**CITY OF ALBUQUERQUE  
PLANNING DEPARTMENT  
April 29, 2015  
DRB Comments**

**PROJECT # 1010403**

**APPLICATION # 15DRB-70164**

**RE: Tract 254 B, MRGCD Map #37**

**PLAT OF
 LAND'S OF LEE AMADOR
 LOT 1 AND 2
 PROJECTED SECTION 17 AND 18, TOWNSHIP 10 N., RANGE 3 E. N.M.P.M.
 BERNALILLO COUNTY, NEW MEXICO
 APRIL 2015**

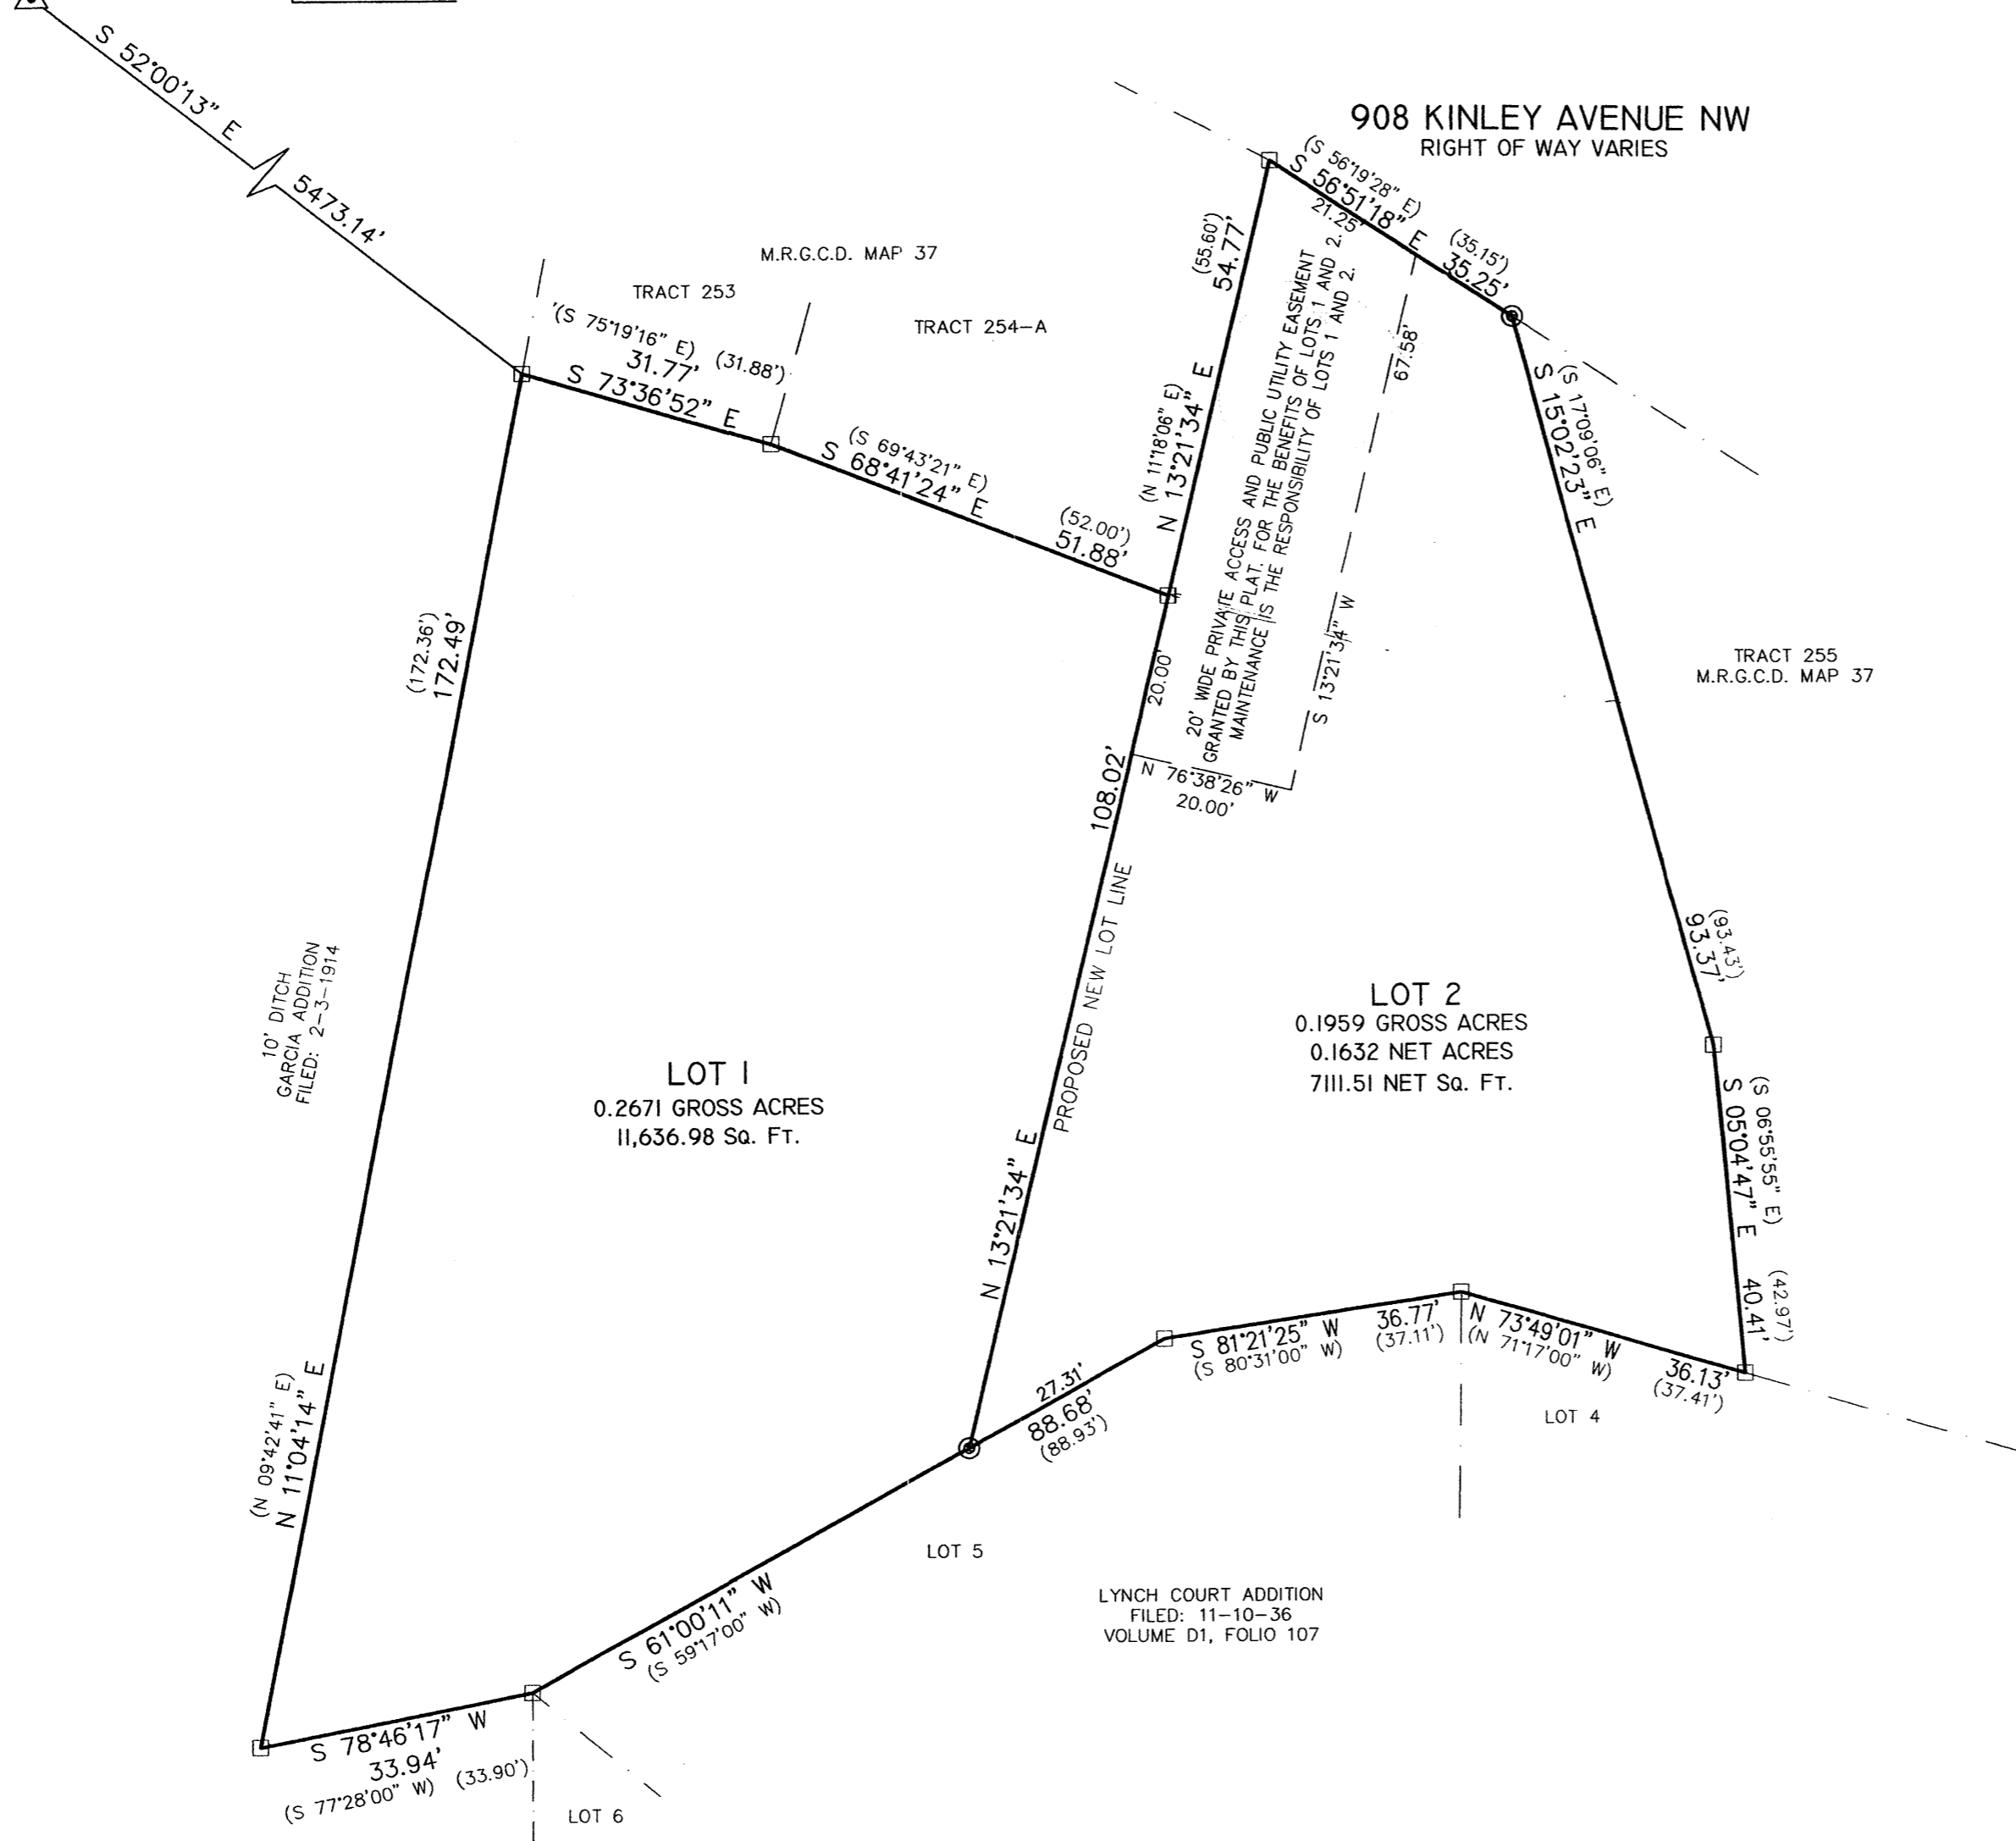
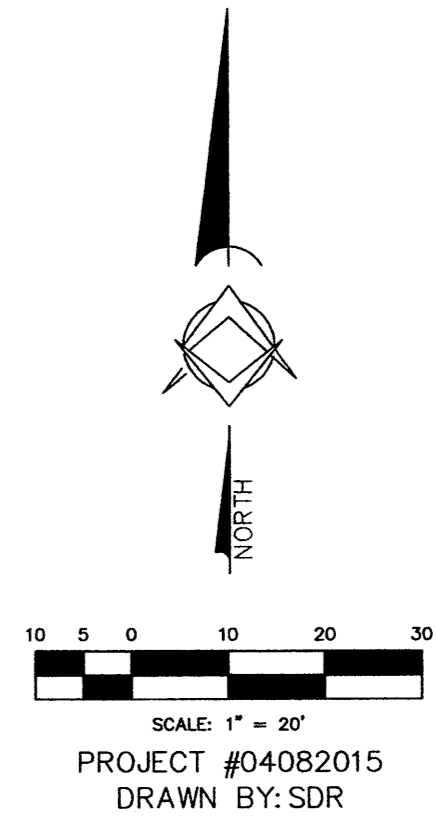
S-R zoning (Sawmill Residential) allows second dwellings on lots 7,000 square feet and larger (pages 97-98, Sawmill Wells Park SDP). Note #9 on the Plat which states "Property is zoned S-R" needs to be deleted since zoning should not be memorialized on a plat. It appears that variances will be needed, for example: sidewalk waiver, sidewalk pavement width, and ROW width (see transportation comments).
